WELWYN HATFIELD COUNCIL – DEVELOPMENT CONTROL
DELEGATED REPORT

APPLICATION No:	S6/2007/1724/MA
------------------------	------------------------

Mymwood House was built as a residential dwelling around 1820 and is a two-storey, detached, white rendered building with a pitched slate roof. Mymwood House has a single storey, flat roofed extension to the rear. The building has been used as a residential care home for the elderly since the mid-1980's and before this had been used as a boarding school from the 1930's. Mymwood house is set back from the highway by approximately 65m. To the front of the site is a detached building Mymwood Lodge. Both Mymwood House and Mymwood Lodge are Grade II Listed Buildings. The site lies within the Metropolitan Green Belt and to the east of the settlement of Brookmans Park.

Drawing Title : Proposed
Sections and Elevations

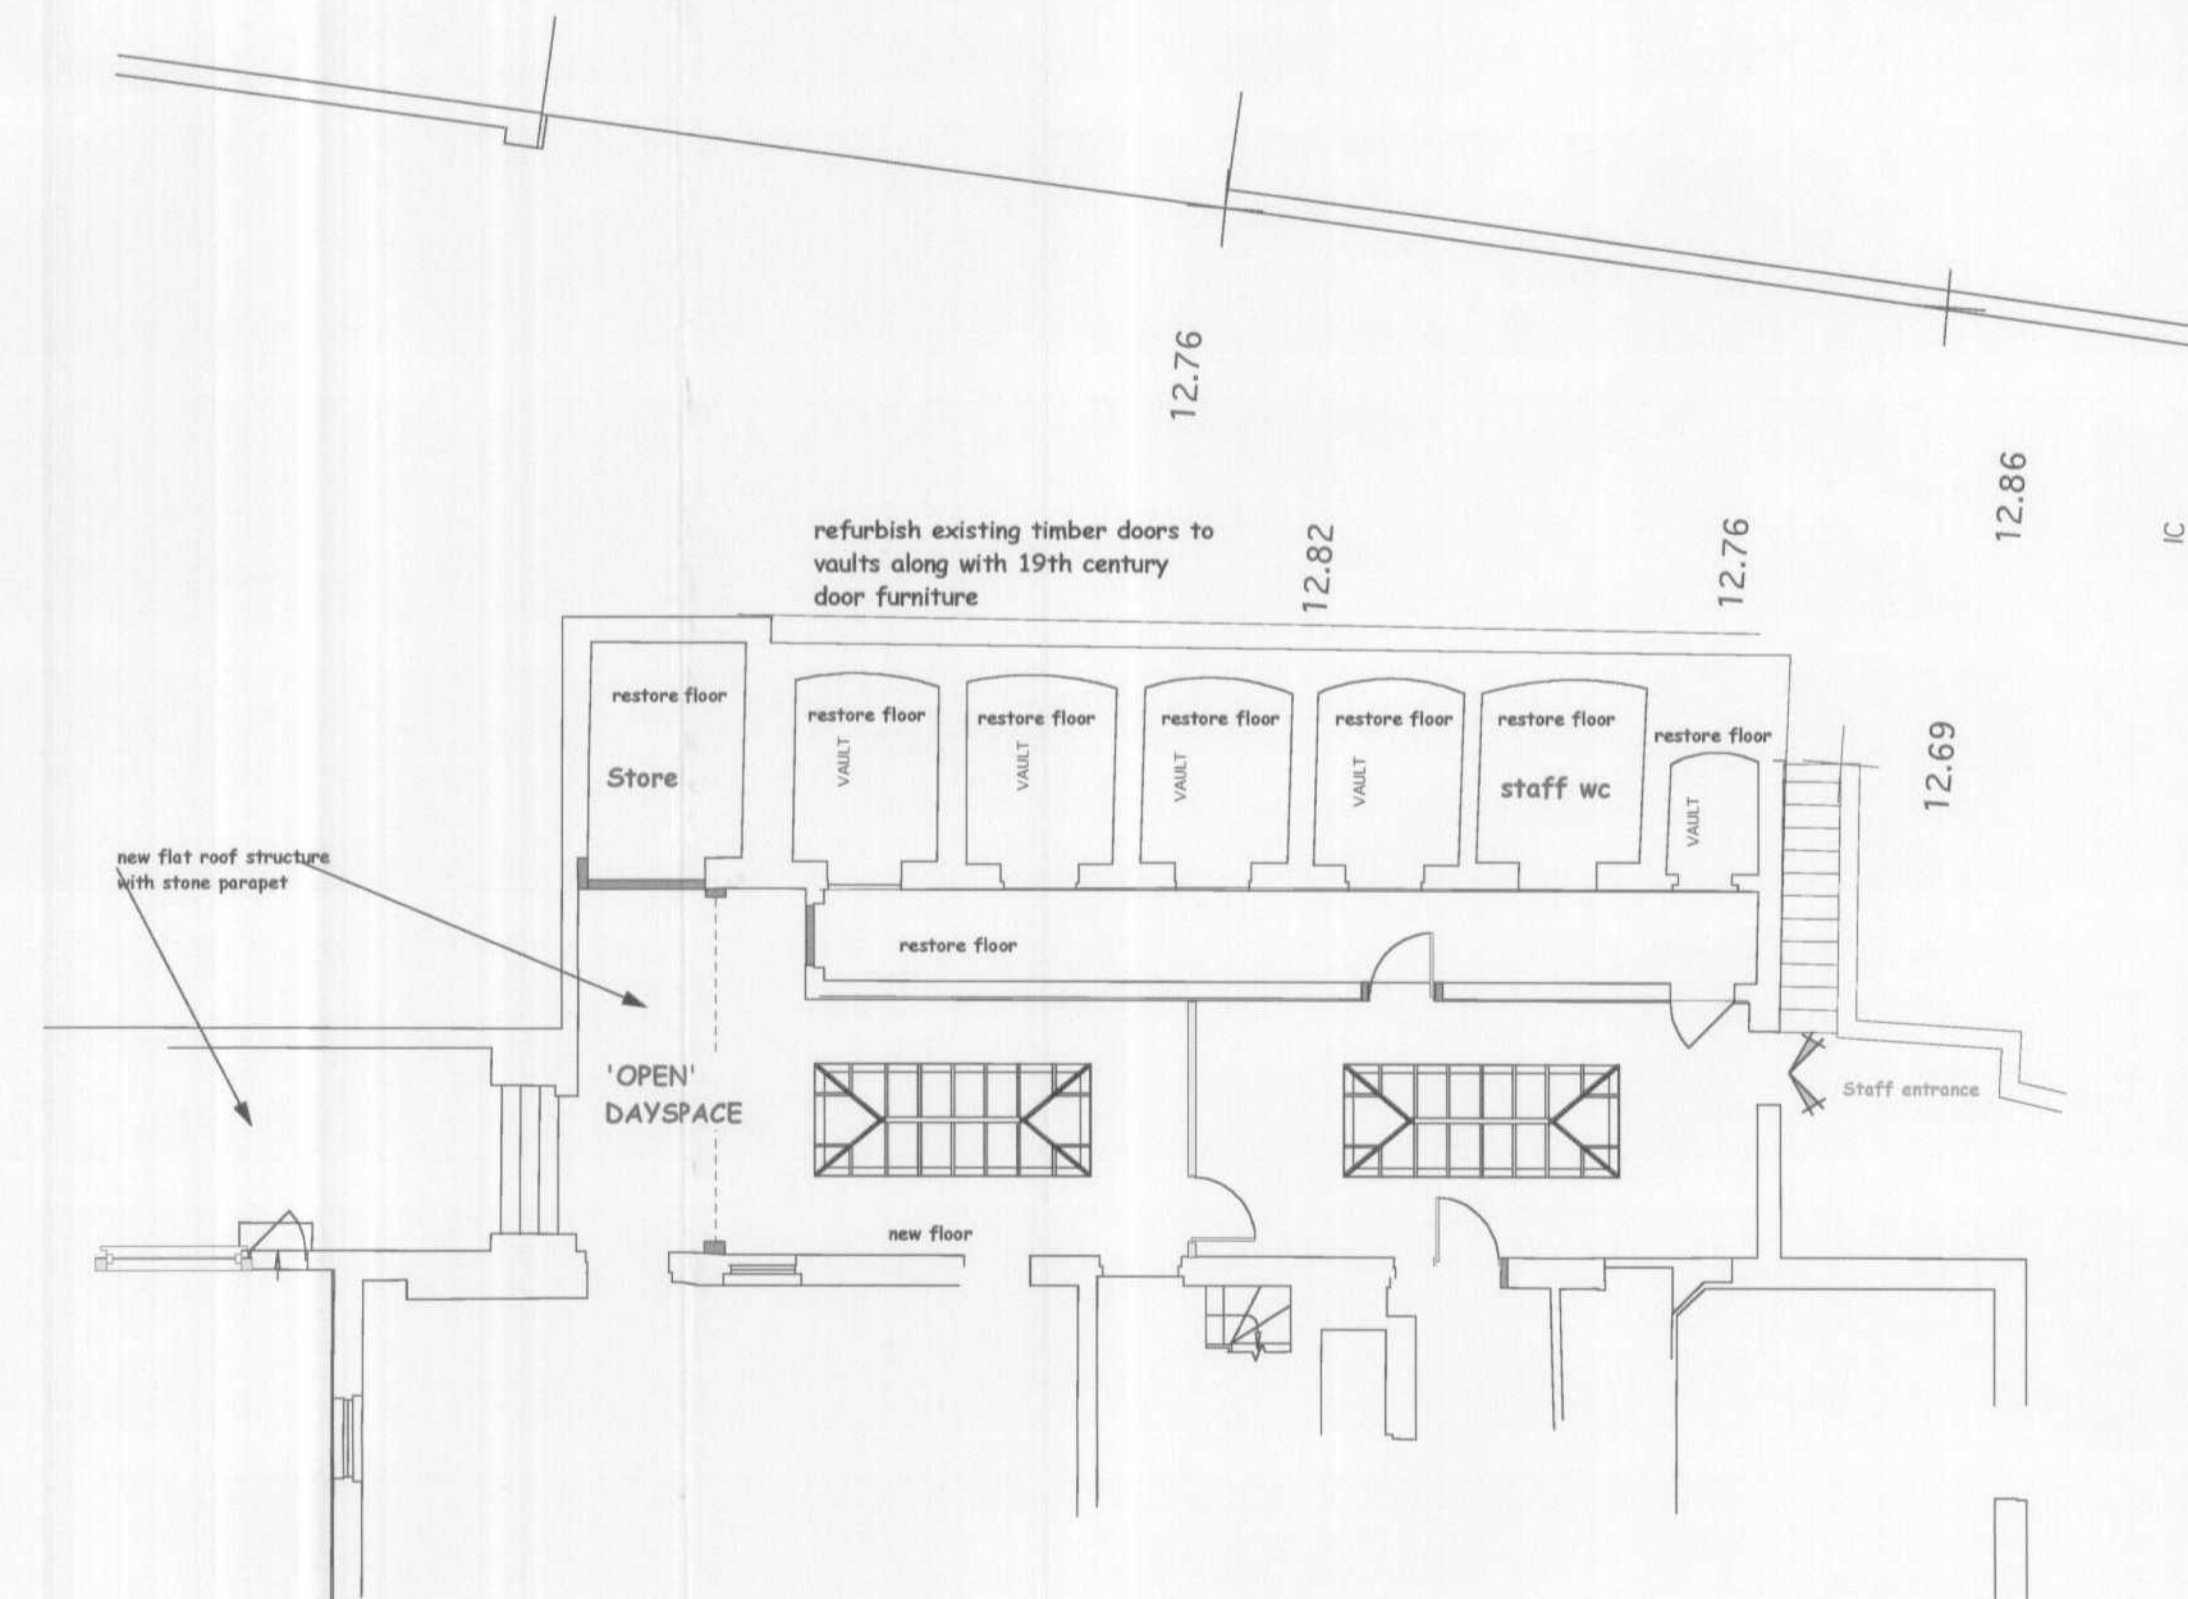
Within the building there is an area which contains 7 vaults which have historic importance. These would be retained with one being converted to be a WC and another being used for storage. The retention of this area is considered to be important and the proposed restoration is considered to be appropriate.
